CITY OF ALBUQUERQUE

November 27, 2024

**Re: Mesa Film Studios
Traffic Impact Analysis
Engineer's Stamp 11-25-24 (D06D100)**

The subject Traffic Impact Analysis (Study) received 11-25-24, has been reviewed and is approved by the City of Albuquerque Planning Development Transportation Section.

Drawing file: Site Plan / 23-0110.001_SDP1.1.pdf

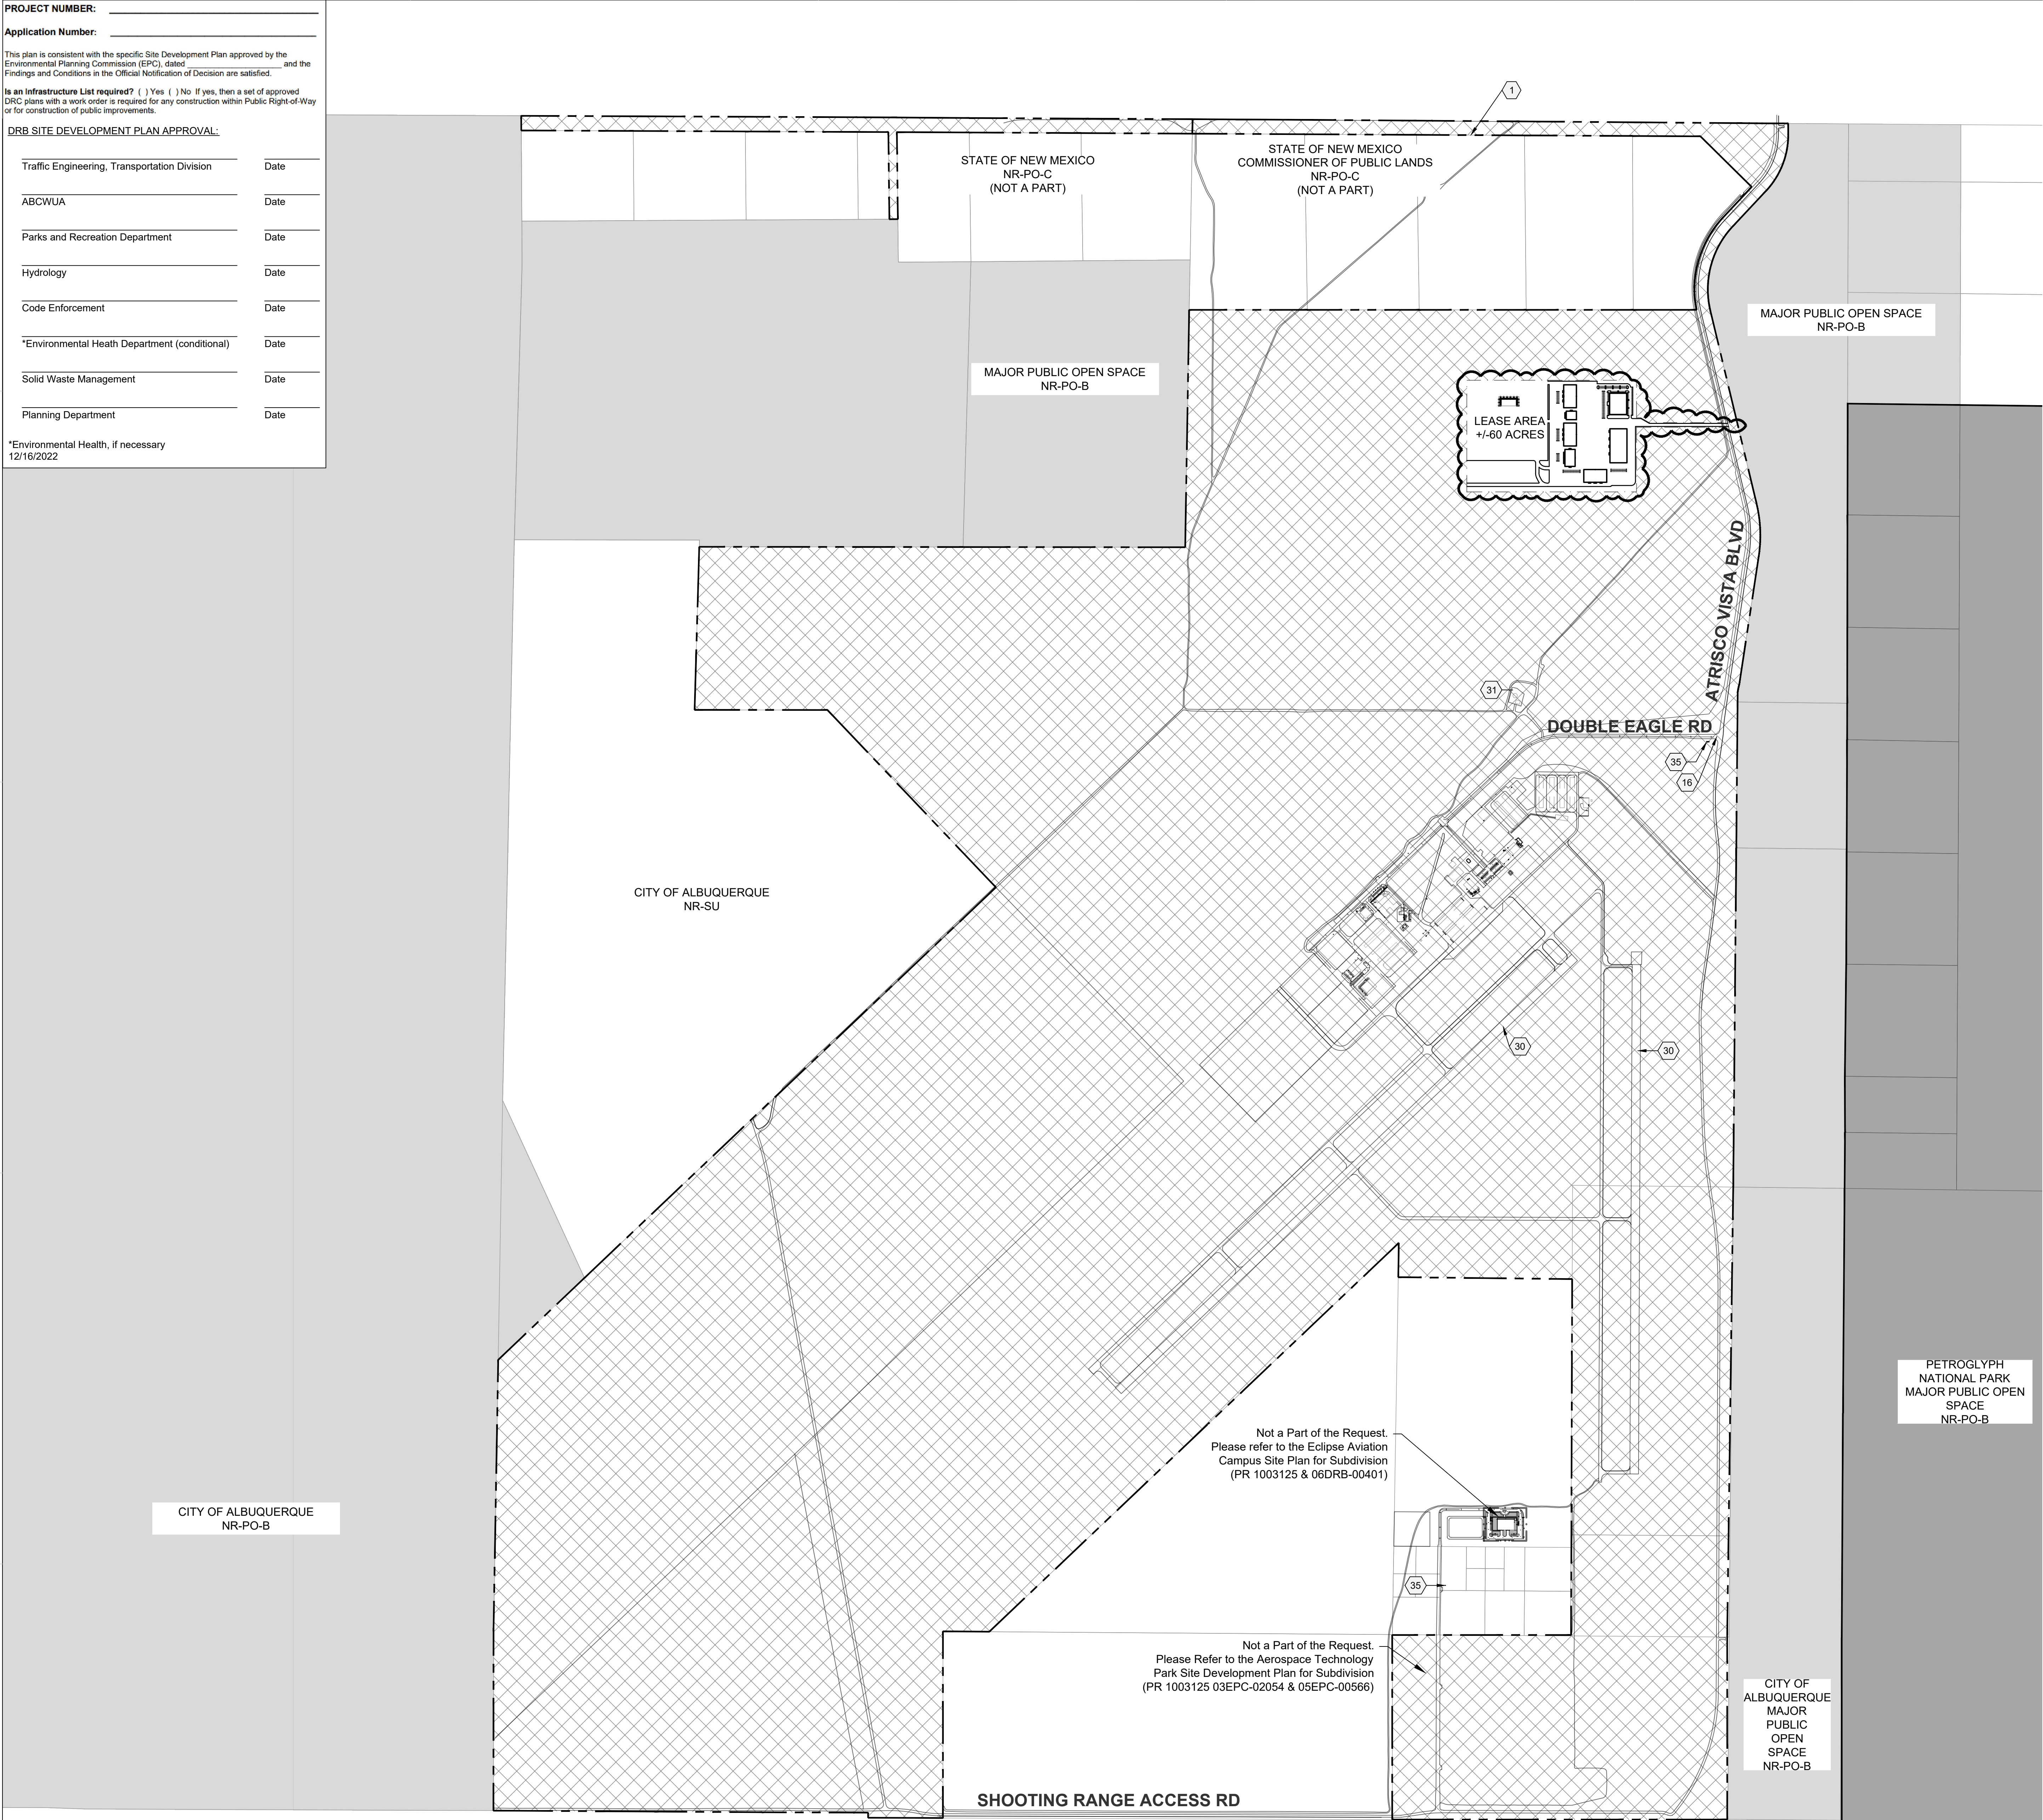
Required infrastructure improvements include the Recommendations discussed on p.20 of the Study and a STOP sign at the site entrance.

Per the MRMPO Roadway Access Control Policy and Inventory of Roadway Access Limitations, "No access permitted except as prescribed by the Double Eagle II Airport Master Plan (Plan)."

Since this access point is not in the Plan, the Plan is to be revised by the Albuquerque Aviation Department who may choose for the revision to be heard by the Environmental Planning Commission. Please see paragraph 6-3(C) of the IDO. Send the approved Plan revision to the City's Traffic Engineer, Curtis Cherne, P.E., so it is clear when to proceed to the next step in the approval process.

After the revision to the Plan is approved, the intersection will have to be approved by the MRMPO Transportation Coordinating Committee.
